PLAN REVIEW SHEET

Date: July 27, 2023

Petition #: 2023-043

The site is located at 1606 Abbey Place that is served by CATS bus route #19 along Park Road.

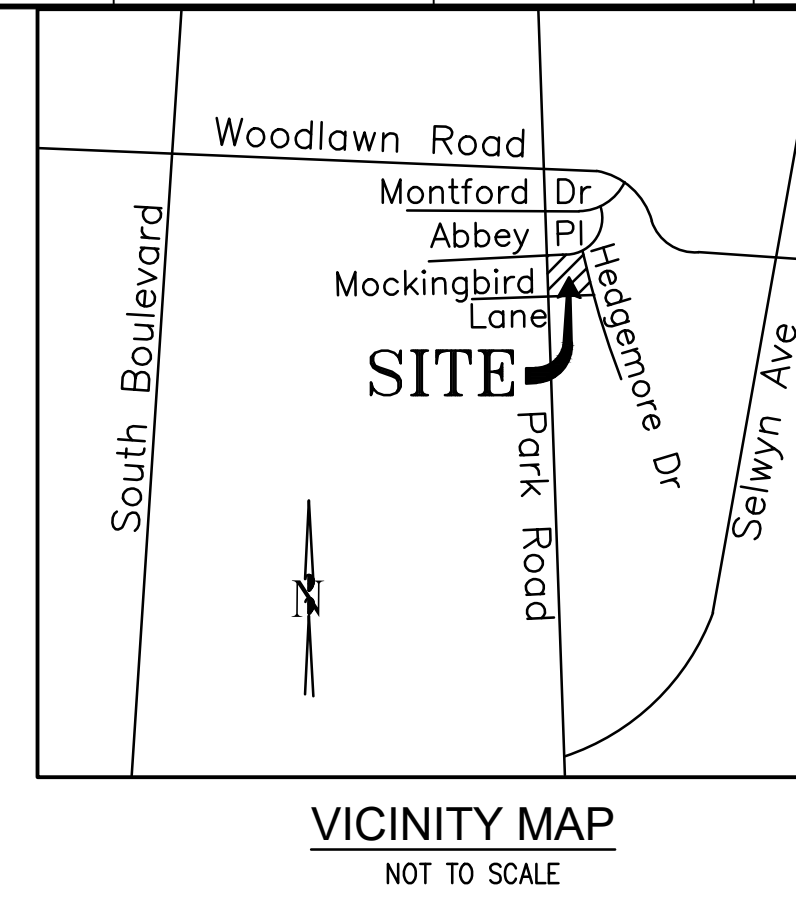
CATS requests amending the site plan to reference the construction of ADA compliant bus shelter pad standard 60.03E on Park Road. The final location will be coordinated with the developer during the Land Development plan review process.
